PROJECT NUMBER: 1010376 - 15DRB-70169 MINOR - PRELIMINARY/ FINAL PLAT APPROVAL

NAME: HUNINGS HIGHLAND ADDITION

**CITY OF ALBUQUERQUE
PLANNING DEPARTMENT
March 4, 2015
DRB Comments**

RE: Lot 3, Block 20, Hunings Highland Addition

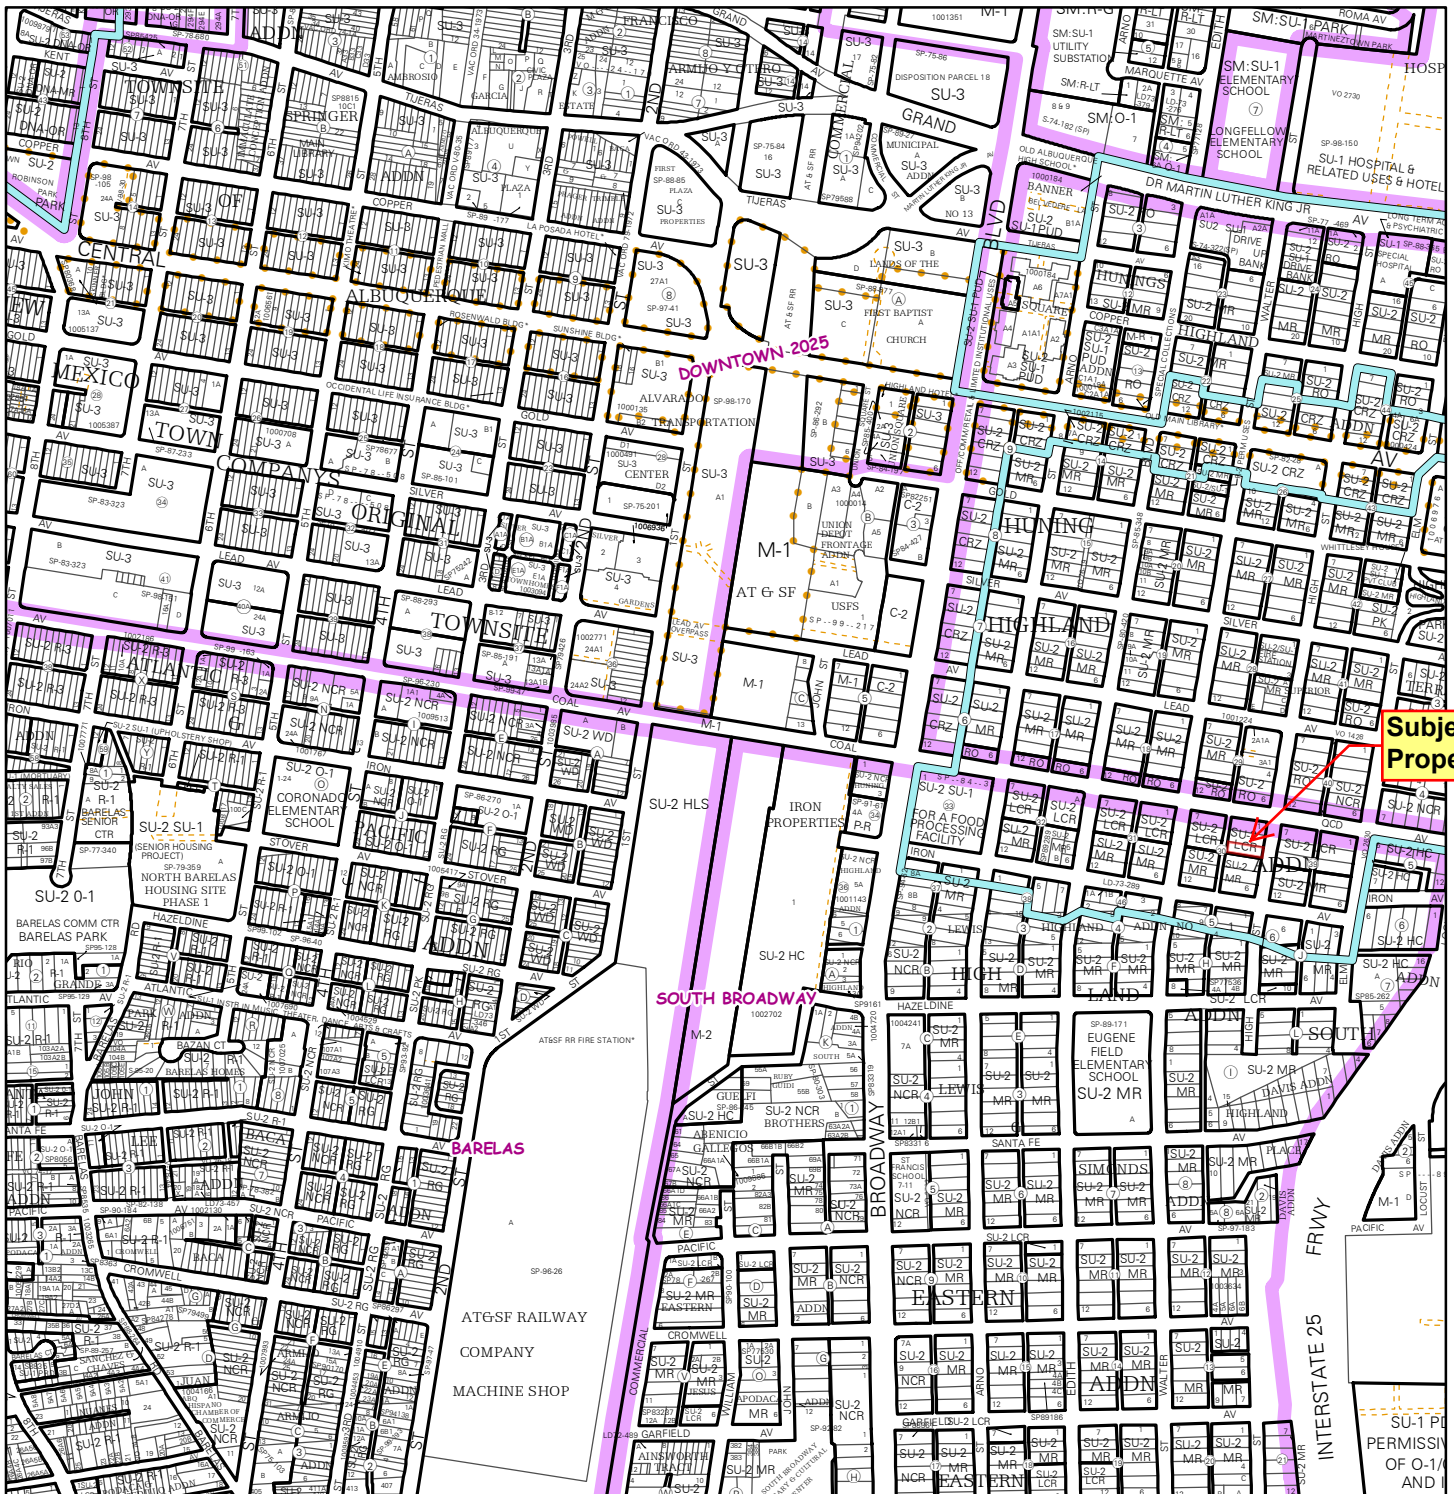
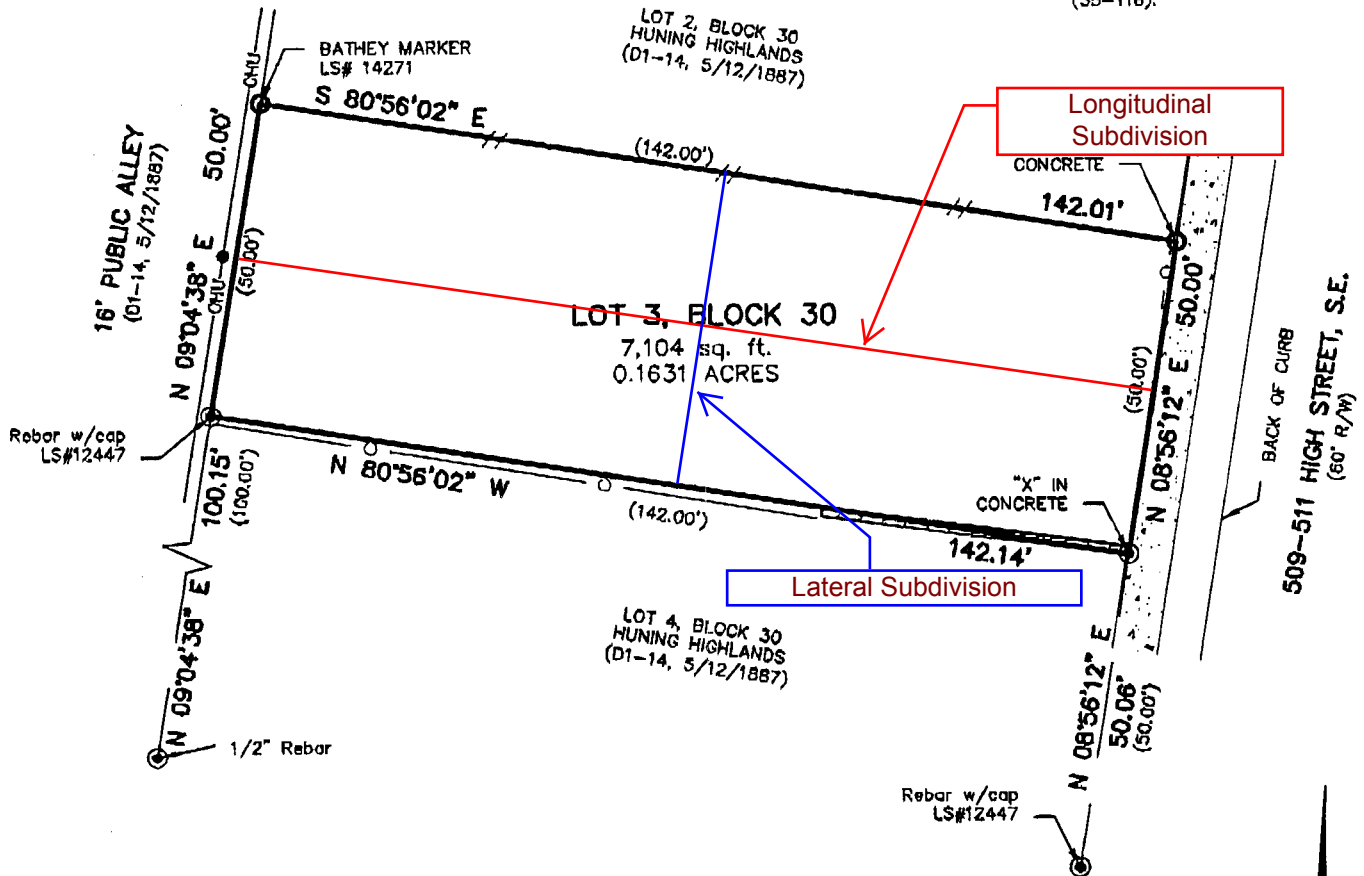
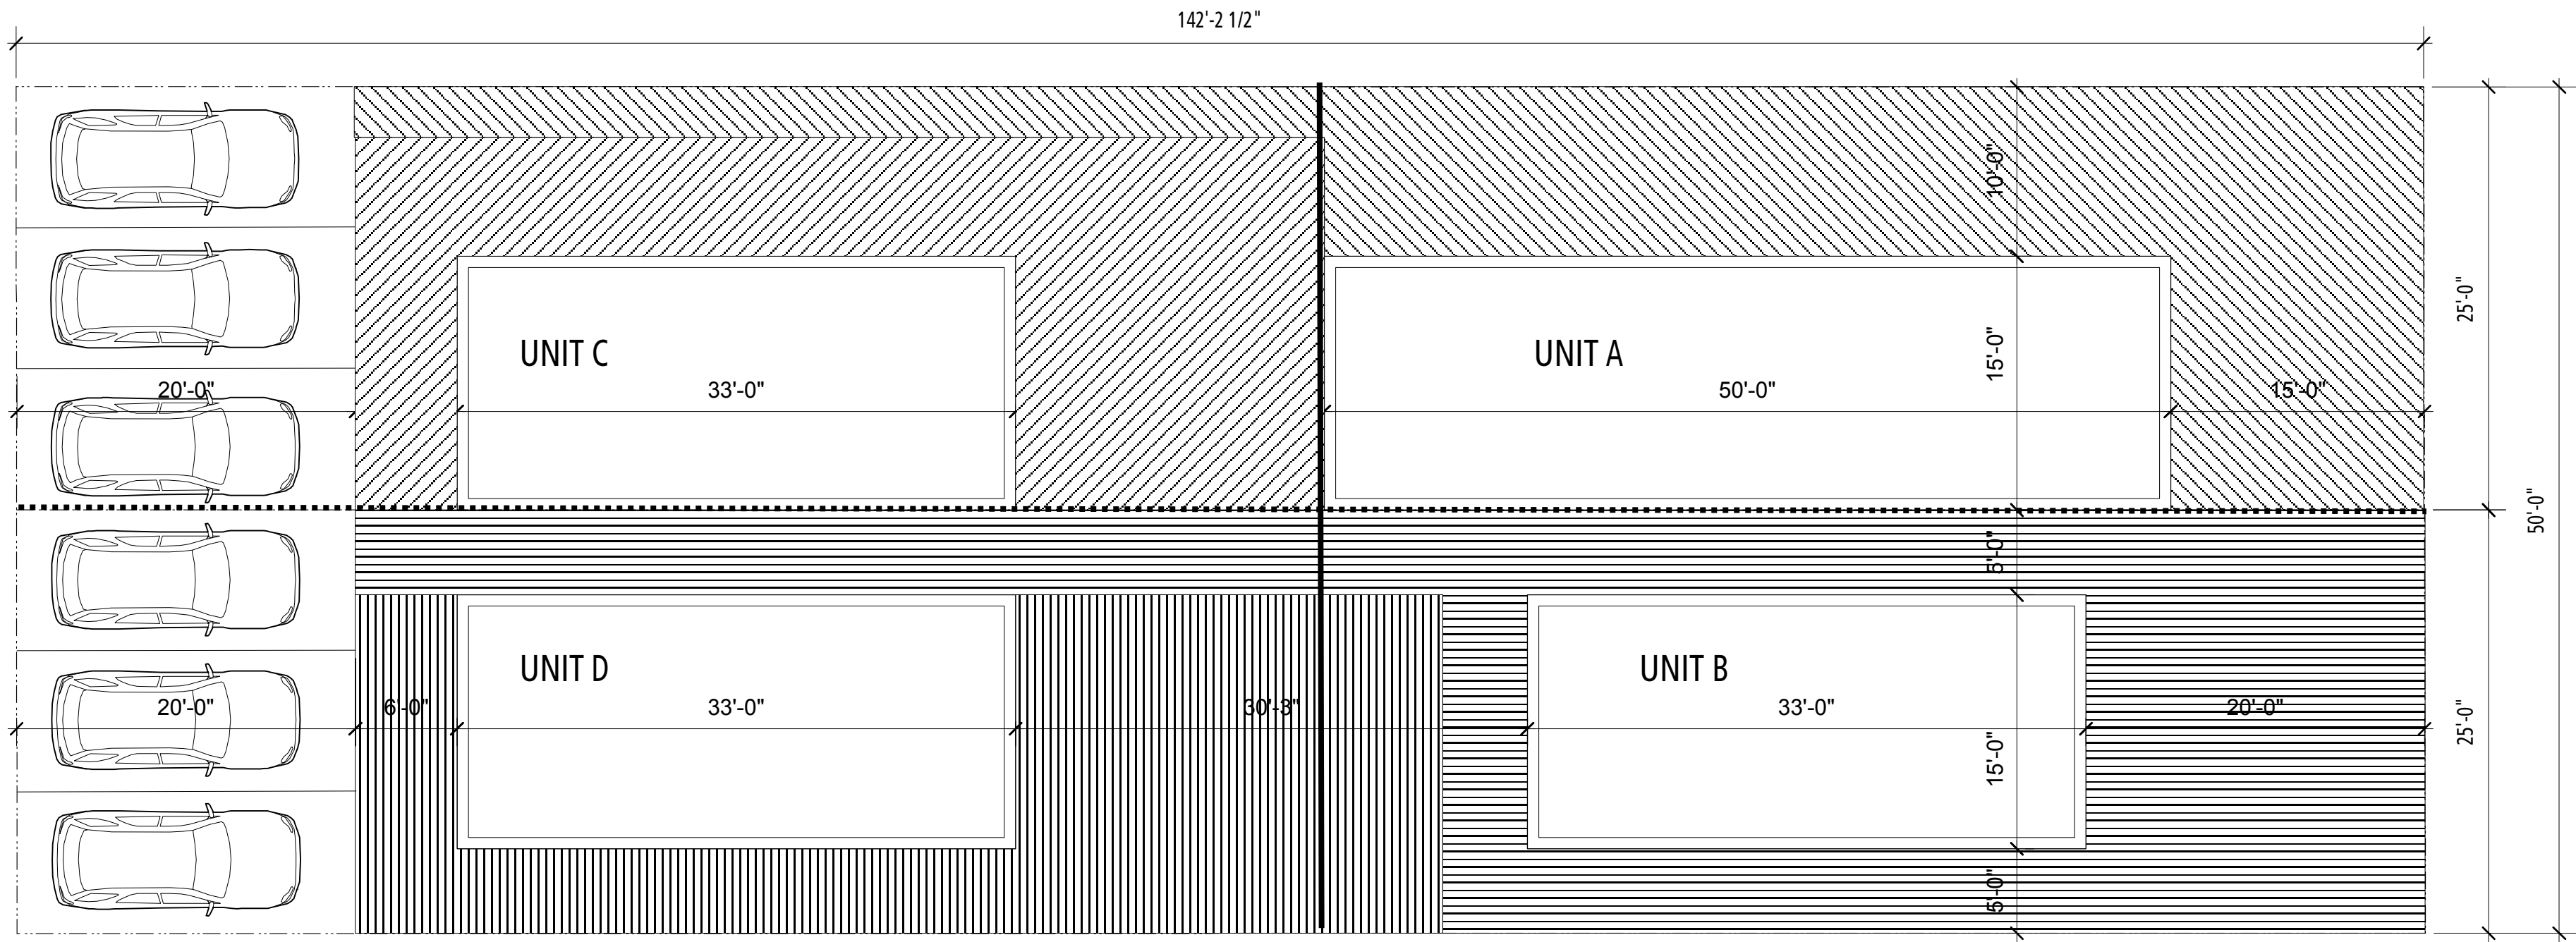
The Zoning Enforcement Officer (Brennon Williams) is the authority on interpreting the Zone Code, and what variances would be needed for the proposed development. Typically, variances to density are not allowed but rather a zone change/ sector plan amendment is required. Zoning Enforcement should verify in writing that the proposed development can proceed prior to platting.

If the tract is divided 'laterally' the project would need a variance for lack of on-site parking on the 'front' lot.
